# CITY OF ALBUQUERQUE

**Re: BEK Distribution Facility (PHASE 1)**  
**601 Gallatin PI NW, 87121**  
**30-Day Temporary Certificate of Occupancy**  
**Transportation Development Final Inspection**  
Engineer's/Architect's Stamp dated 7-29-19 (J10D002G1)  
Certification dated 5-13-21

Ernie Gomez,  
Plan Checker, Planning Dept.  
Development Review Services

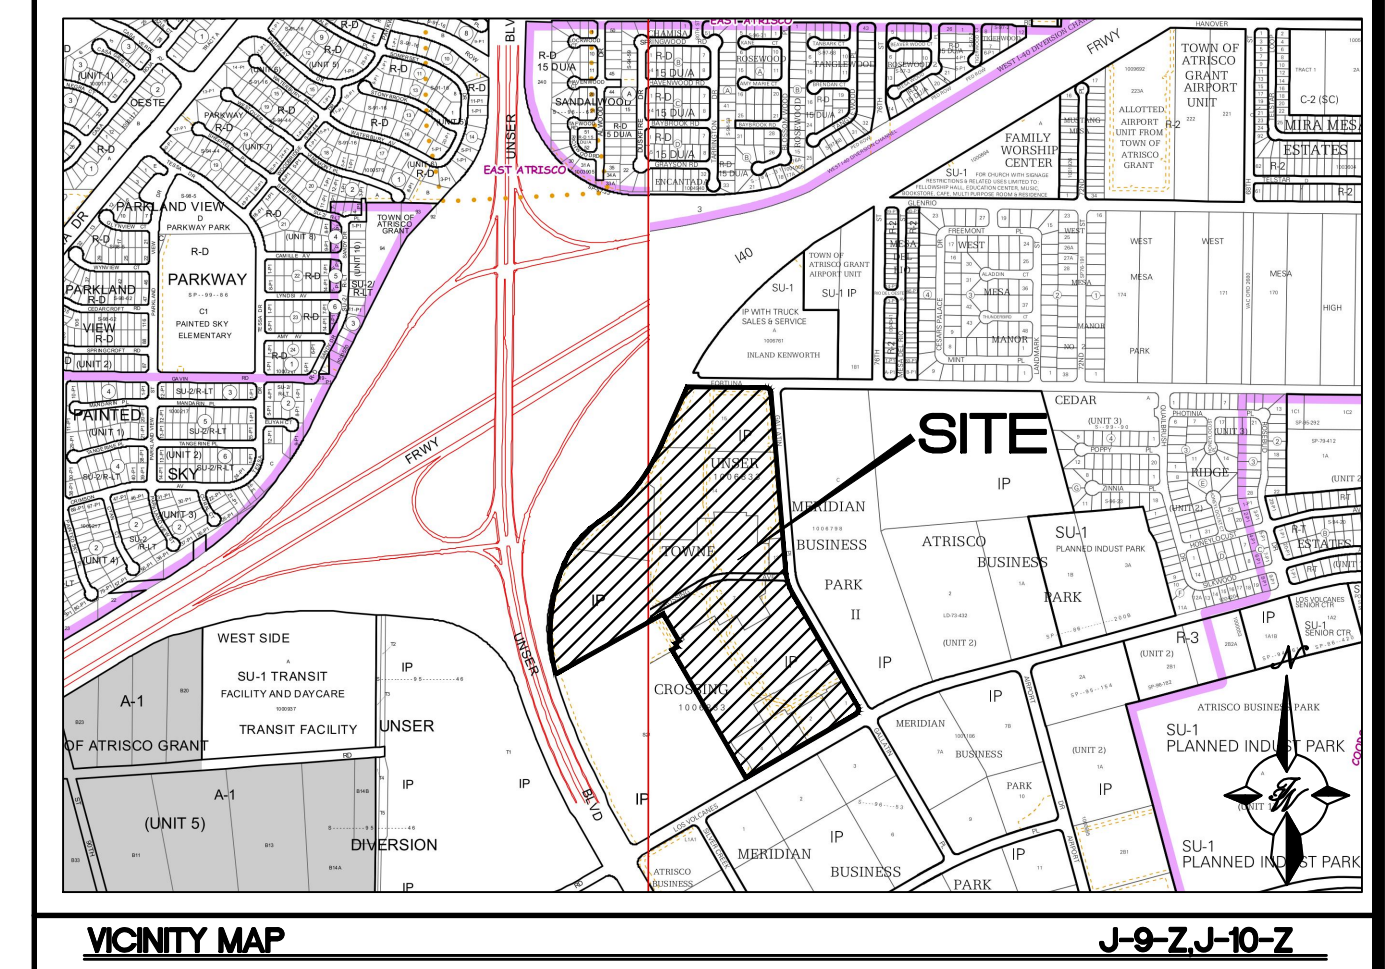
1. The ADA access aisles shall have the words "**NO PARKING**" in capital letters, each of which shall be at least one foot high and at least two inches wide, placed at the rear of the parking space so as to be close to where an adjacent vehicle's rear tire would be placed. (66-1-4.1.B NMSA 1978)
2. Van accessible aisles should be 8ft wide; all others should be 5ft wide.
